Online Comment

Application H16-0790-21
Location 32-33 Hall Place Spalding PE11 1SG
Proposal Proposed Signage

Name Greg Watkinson
Address Conservation Officer

EXISTING SHOPFRONT ELEVATION

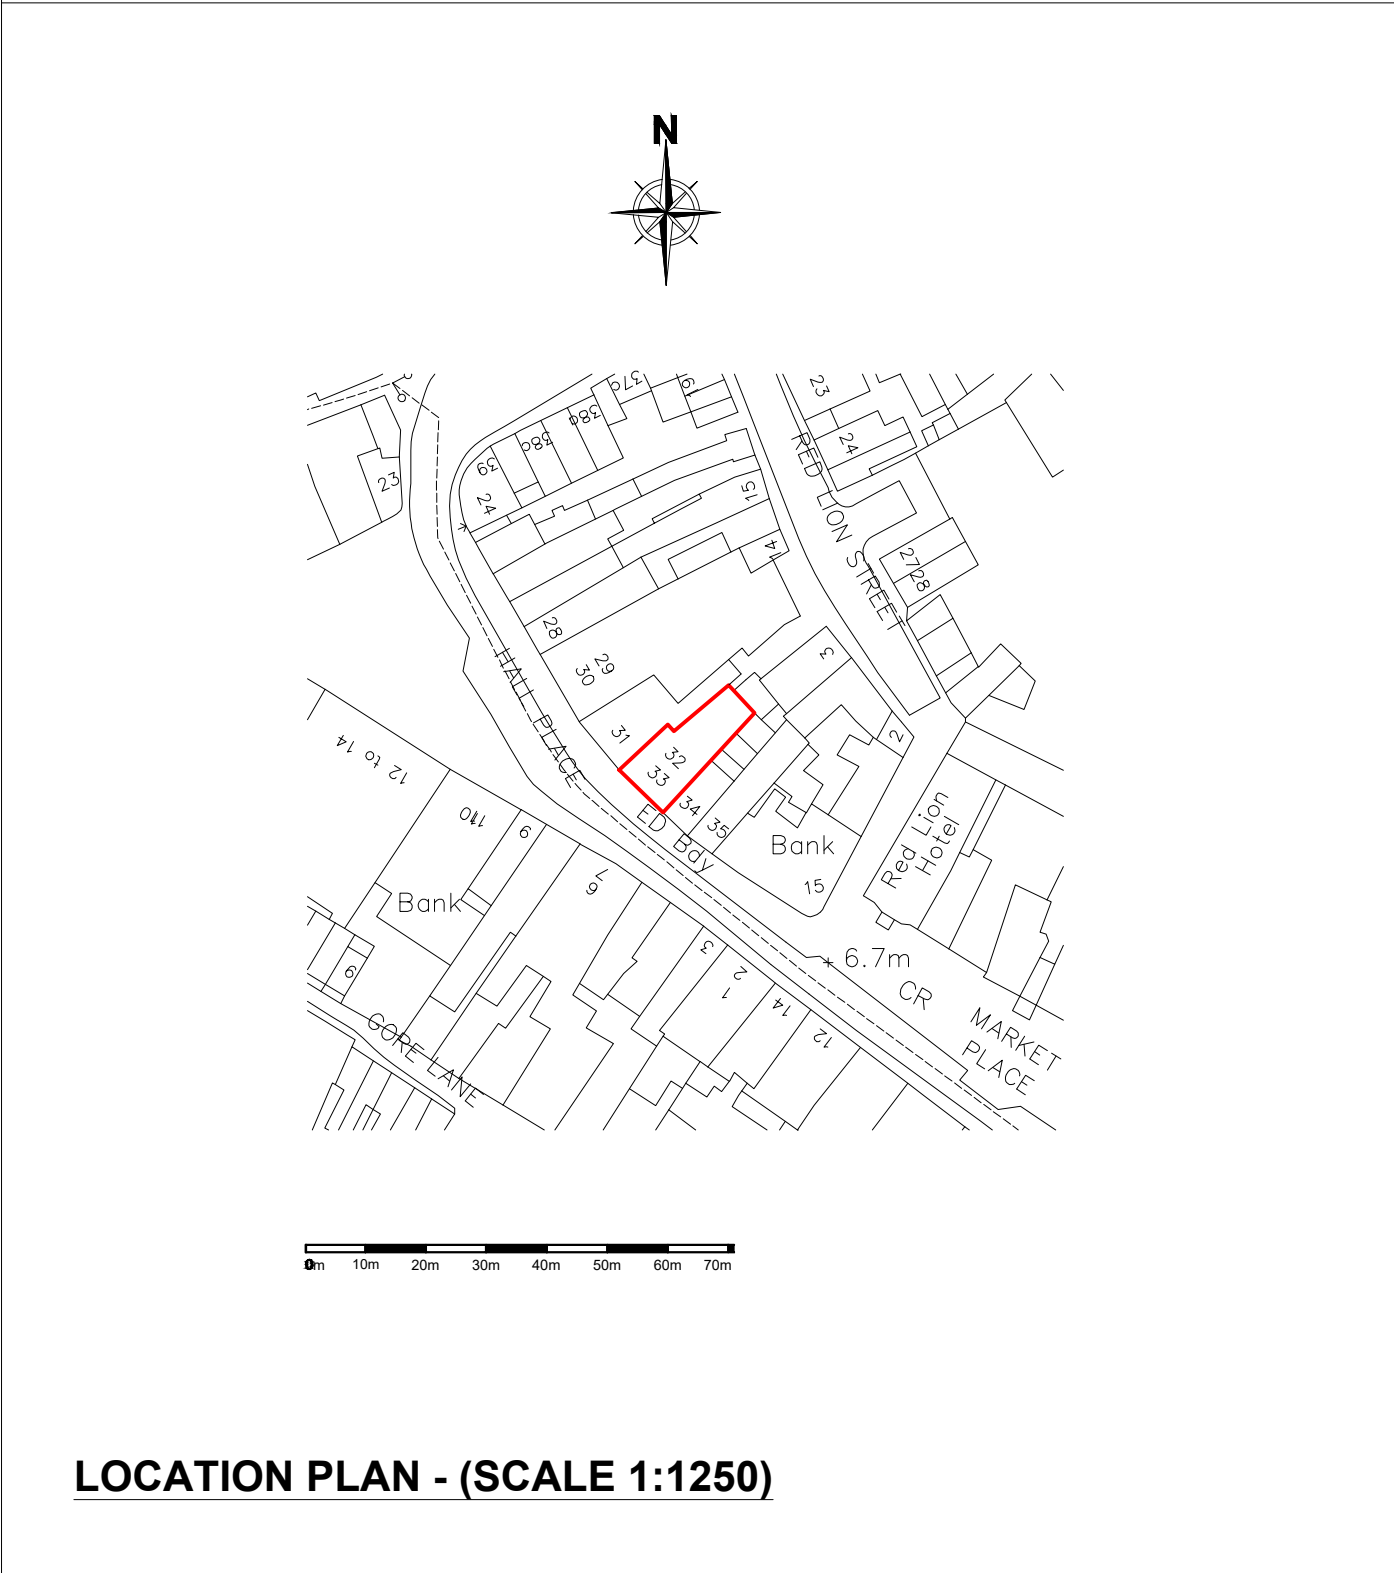
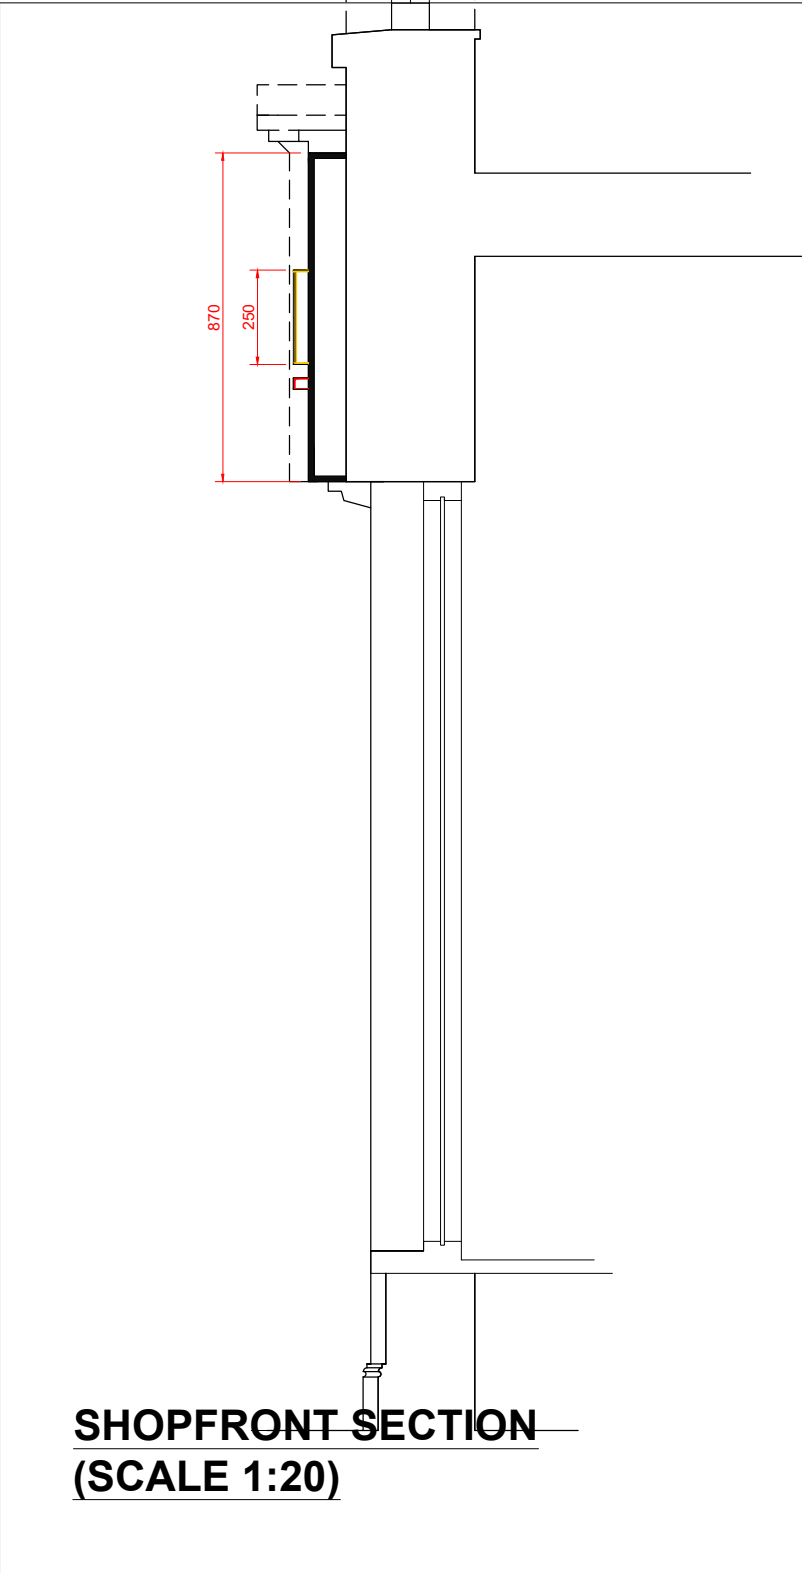
From a Conservation perspective, I do not feel that the proposed signage is appropriate in design and construction for the Conservation Area setting, especially in such a prominent portion of the primary shopping area of Spalding.

The proposed restoration of the pilaster details and the avoidance of direct application vinyl is appreciated. However, I believe that cumulatively, the modern, somewhat characterless design of the signage and the bold, bright colour scheme (notwithstanding the black background) are at odds with the aims of Policy 29 of the South East Lincolnshire Local Plan, in that they do nothing to assist in the enhancement of the character and distinctiveness of the Spalding townscape. A more carefully considered, heritage focussed proposal, that was commensurate with the Conservation Area would be far more preferable.

Additionally, I note that it is proposed that the signage would be internally illuminated, which is again, at odds with the standard of the conservation area. Apart from in exceptional circumstances, internally illuminated signage is not generally considered to be appropriate for signage in a conservation area owing to the fact that it completely alters and modernises the character of a townscape, especially at night. As such, I would suggest that any successful proposal should only include external illumination methods.
